**KIRKLEES METROPOLITAN COUNCIL
INVESTMENT & REGENERATION SERVICE**

DELEGATED DECISION TO DETERMINE PLANNING APPLICATIONS

Reference No:	2025/62/91986/W
Site Address:	7, Edgerton Green, Edgerton, Huddersfield, HD1 5RD
Description:	Erection of two storey extensions and front and rear dormers
Recommending Officer:	Jennifer Booth

OFFICER REPORT

PROPOSED GROUND FLOOR PLAN.
SCALE 1:50.

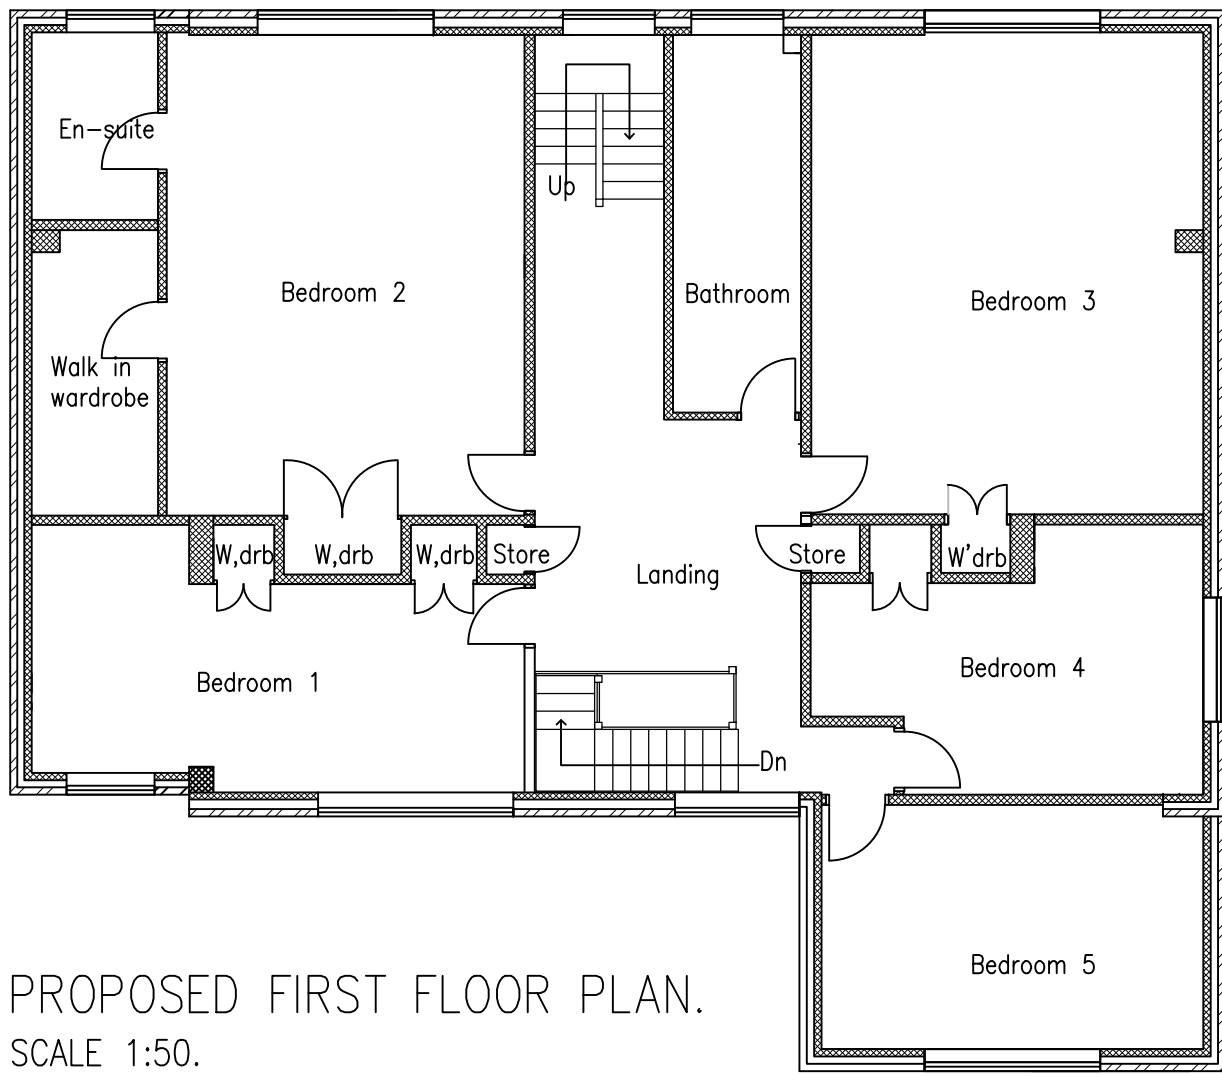
The scheme includes single and two storey extensions to the sides and rear which result in an overall depth of the main house of 11.9m on the ground floor reducing to 10.9m and width of 16.5m. the roof over each of the side extensions would be pitched at 0.2m lower than the main roof with a lean to over the ground floor element. The walls would be constructed using blockwork and render with tiles for the roof covering.

The proposals will result in some intensification of the domestic use and the reduction in usable space within the integral, double garage. It is noted that the current garages are not of a sufficient size to constitute parking against modern standard. However, the property has parking to the front for at least three vehicles which is considered to represent a sufficient provision. Bin storage for the dwelling would not be moved as part of the proposals. As such the scheme would not represent any additional harm in terms of highway safety and as such complies with Policy LP22 of the Kirklees Local Plan along with Key Design Principles 15 & 16 of the House Extensions & Alterations SPD.

PROPOSED FRONT ELEVATION
SCALE 1:100

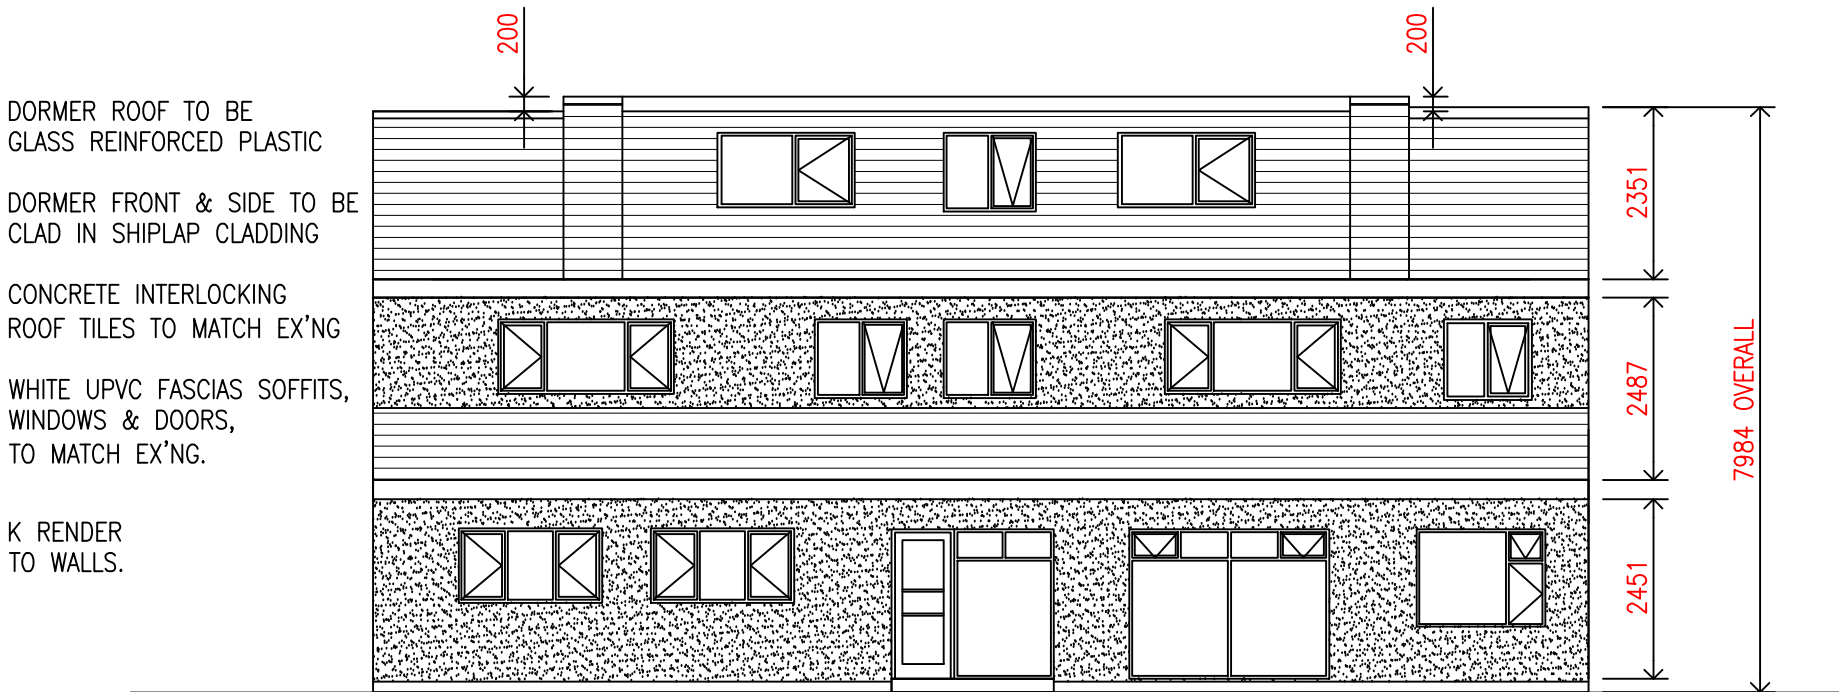
The front porch would have a projection of 1.6m and a width of 3.9m with a lean to roof form.

The first floor front extension would project 3.5m with a width of 5.8m over the existing garages. The roof form would be a perpendicular pitched roof form.

The plans include two dormers within the front roof plane each with a width of 2.5m and an overall height of 1.8m with pitched roof forms.

The front porch would be modest in terms of its size and would be constructed using matching materials with render for the walling and tiles for the roof covering. The porch is therefore considered to be acceptable in terms of visual amenity.

The first floor front extension over the garage would follow the footprint of the existing garage. Whilst the extension is sizeable, it would form an appropriate relationship with the host property. The use of a road facing gable would mimic other properties in the street scene. The materials proposed include the use of render for the walling with tiles for the roof covering which would match the overall alterations to the main house. The first floor front extension is considered to be acceptable in terms of visual amenity.

The front dormers would both be modest in terms of their size and appropriate in terms of the materials. As such, the front dormers are considered to be acceptable in terms of visual amenity.

The rear dormer would have a width of 9.9m and a height of 3m with horizontal boarding.

The proposed reduction in the width of the rear dormer represents a significant improvement in the overall design approach. By decreasing its scale and massing, the dormer now sits more comfortably within the context of the existing roof form and the other proposed extensions. This adjustment ensures that the cumulative impact of the roof alterations is more balanced, resulting in a less bulky and more proportionate addition to the dwelling.

The revised dormer design is now more subservient to the main roof, avoiding dominance over the rear roof plane and helping to maintain a harmonious and well-integrated appearance. This careful consideration of scale and proportion enhances the architectural integrity of the property and supports the visual amenity of both the surrounding area and the street scene.

As a result, the amended rear dormer is more closely aligned with the guidance outlined in the SPD and is considered acceptable in terms of visual amenity.

PROPOSED SIDE ELEVATION
SCALE 1:100

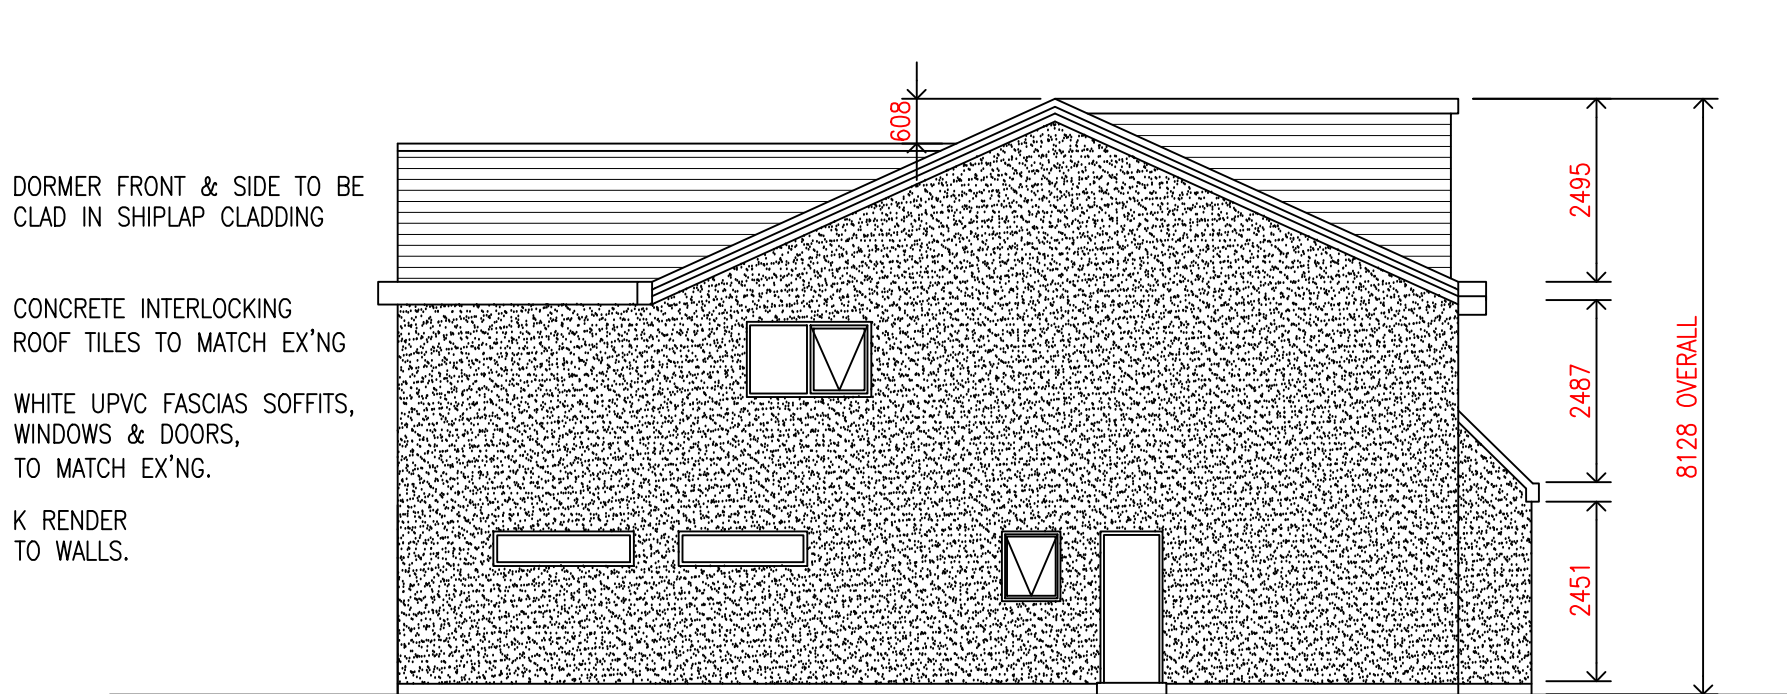
The proposed increase in the footprint of the host dwelling will result in a materially larger built form positioned approximately 1.2m from the shared boundary with the adjacent property to the south-west, and approximately 6m from the neighbouring dwelling itself. The host property is broadly aligned with the rear garden area of the neighbouring property, and land levels appear to be similar, resulting in a direct and open relationship between the two plots.

Given the proximity of the proposed extension to the boundary and its increased massing, some degree of visual change would be perceptible from the neighbouring garden and ground floor rear-facing windows. However, the separation between the two dwellings provides a reasonable buffer that significantly reduces any sense of enclosure or undue dominance. In addition, the presence of the existing dwelling already establishes a built form along this part of the boundary, which helps to mitigate the overall impact of the proposed extension.

The lack of windows in the proposed side elevation further ensures that there would be no material loss of privacy, and the degree of overshadowing is unlikely to be significant given the orientation and spacing between the properties. While the extension would increase the visual presence of built form near the boundary, the overall impact on the neighbouring property's private outdoor space is not considered to be unacceptably overbearing in the context of the existing arrangement and separation.

PROPOSED SIDE ELEVATION
SCALE 1:100

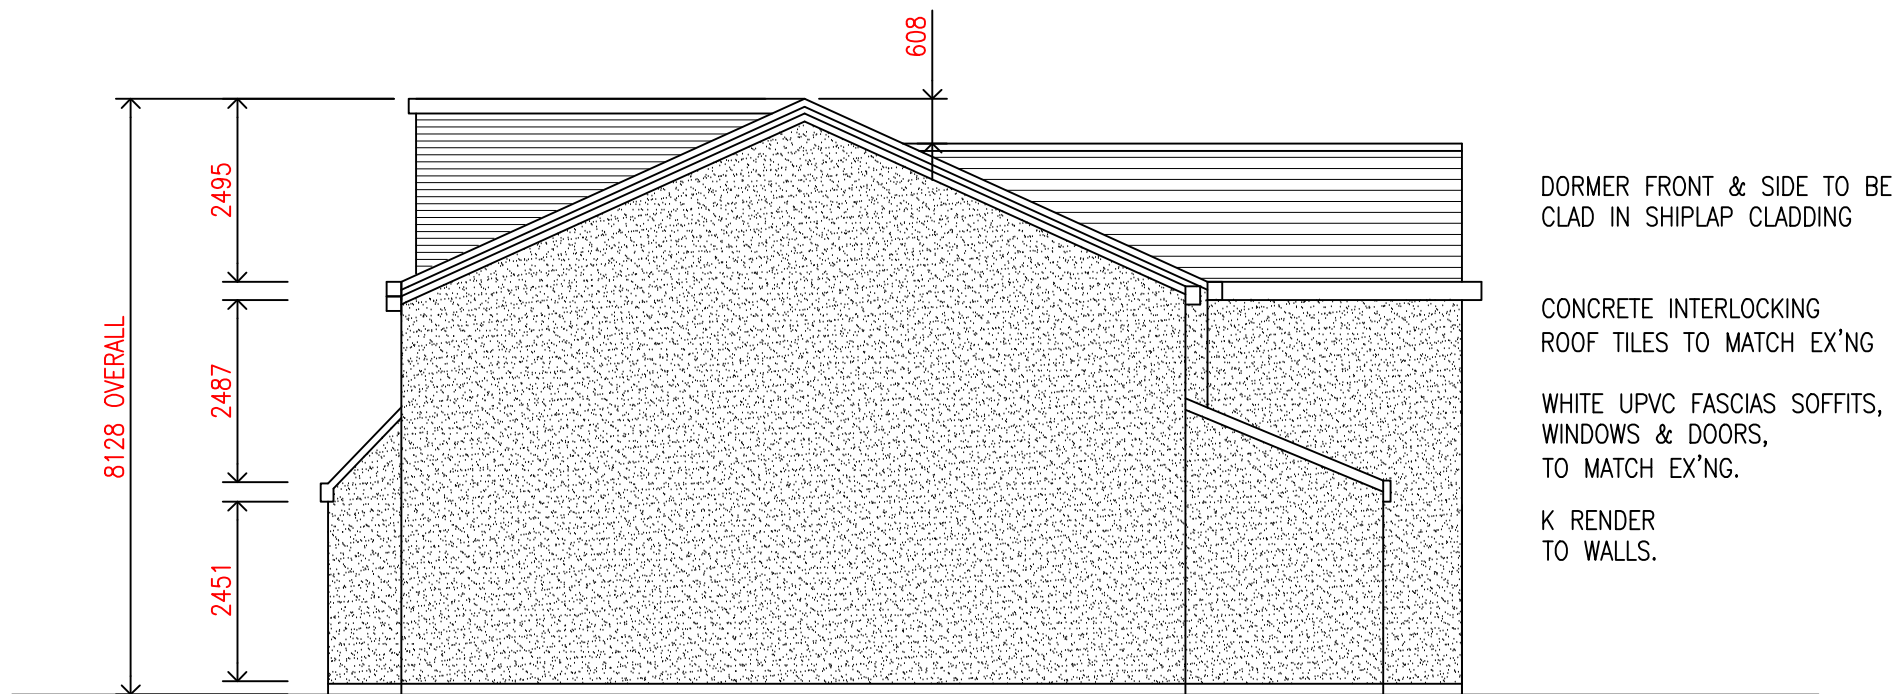
The proposed increase in the footprint of the host dwelling would position the extended built form approximately 1.2m from the shared boundary and around 6m from the neighbouring dwelling to the north-east. The host property is aligned with the front garden of the adjacent property, and land levels appear to be similar, providing a broadly even relationship between the two sites.

Given the intervening distance between the two dwellings and the fact that the extension would be located opposite the front garden of the neighbouring property rather than more sensitive private amenity space to the rear, the impact in terms of overbearing and enclosure is considered to be limited. Furthermore, the existing form of the host dwelling already establishes a visual presence along this part of the boundary, which would help to mitigate the perceived effect of the additional built form.

While the development would introduce a degree of visual change when viewed from the neighbouring garden and frontage, the separation between the properties, combined with the orientation and existing relationship, would prevent the extension from appearing unduly dominant or oppressive.

The proposed extension includes several openings within the side elevation facing No. 8, most of which replicate existing window positions and therefore do not introduce new opportunities for overlooking. This elevation faces the front garden of No. 8, which is not afforded the same level of privacy as rear amenity space.

As part of the internal reconfiguration, the removal of the front-facing window to Bedroom 4 and its replacement with a side-facing window is not considered to result in any material loss of privacy, given its outlook towards the less sensitive front garden area. Overall, the proposal is considered to have a neutral impact on privacy in relation to No. 8.

PROPOSED SITE PLAN.
SCALE 1:200

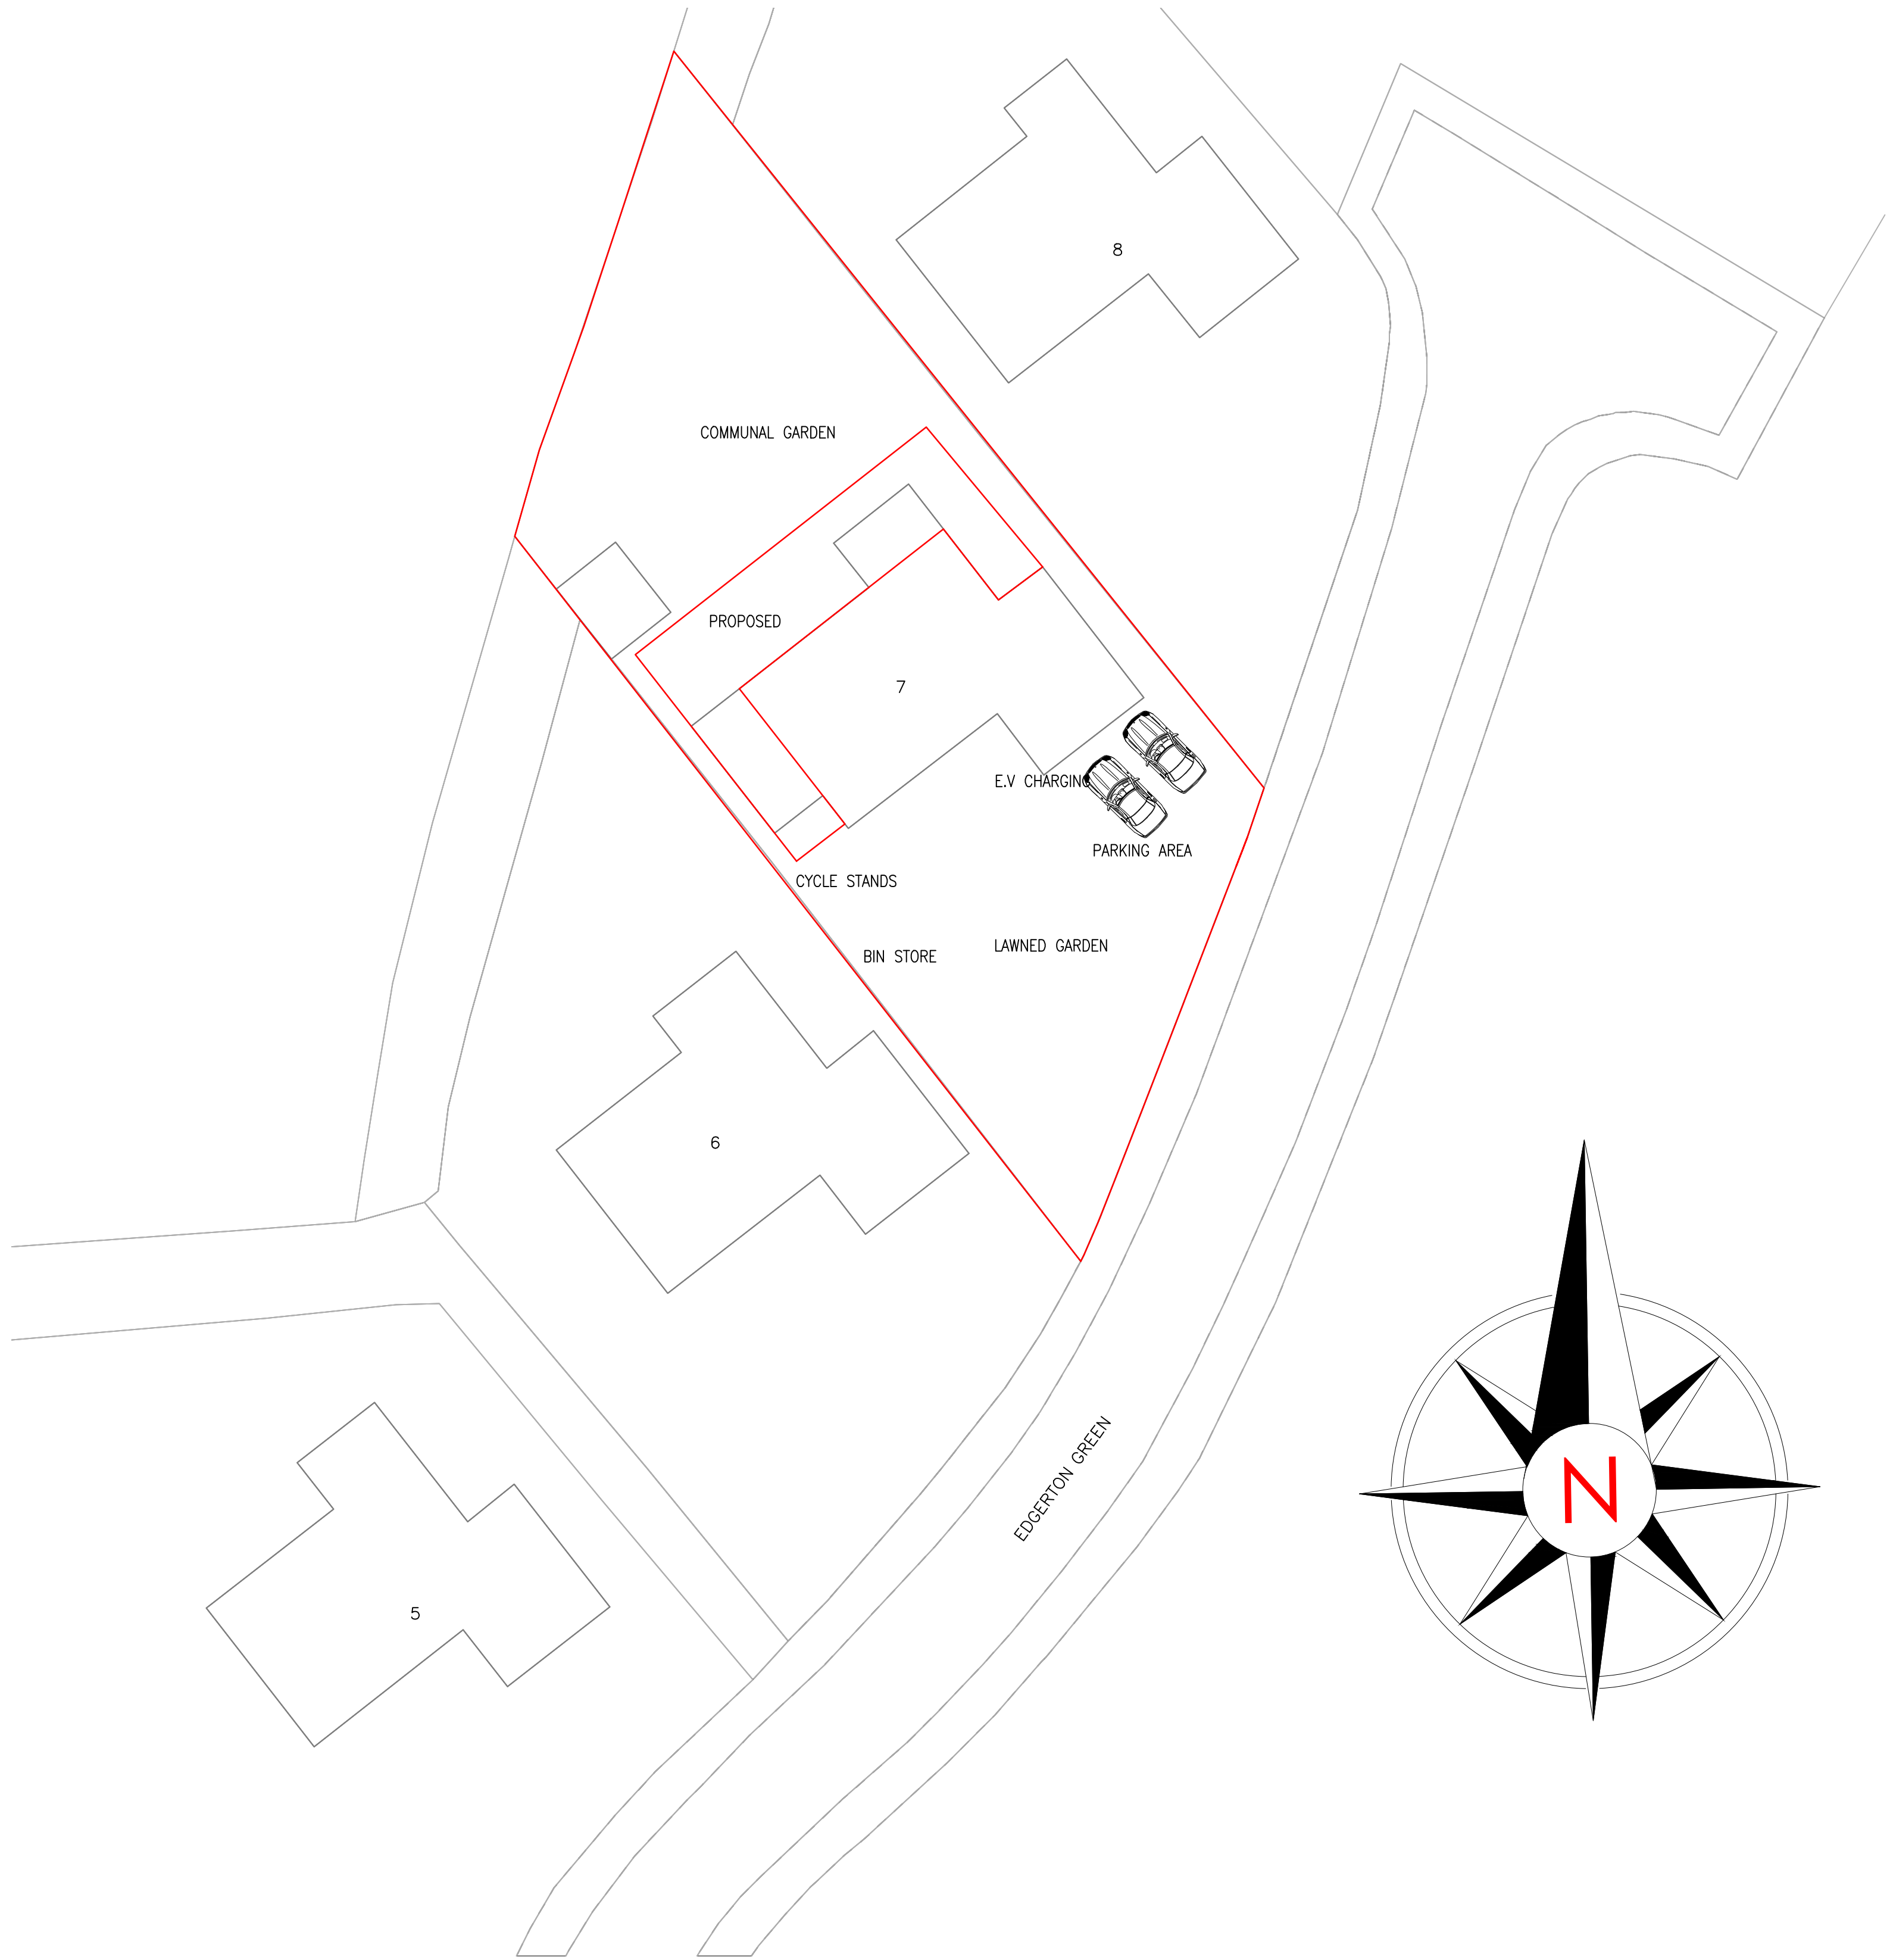
The proposed development would be sited in close proximity to a ribbon of protected trees located along the rear boundary of the site. These trees are subject to a Tree Preservation Order and contribute positively to the character and amenity of the area. The agent has supplied a tree survey which concludes that none of the trees would be impacted by the development. Subject to a condition that the development should be carried out in accordance with the findings of the tree survey, the proposal are considered comply with Policy LP33 of the Kirklees Local Plan and the aims of Chapter 15 of the National Planning Policy Framework.

4. The development shall be carried out in accordance with the details provided in the tree survey submitted 07/10/2025.
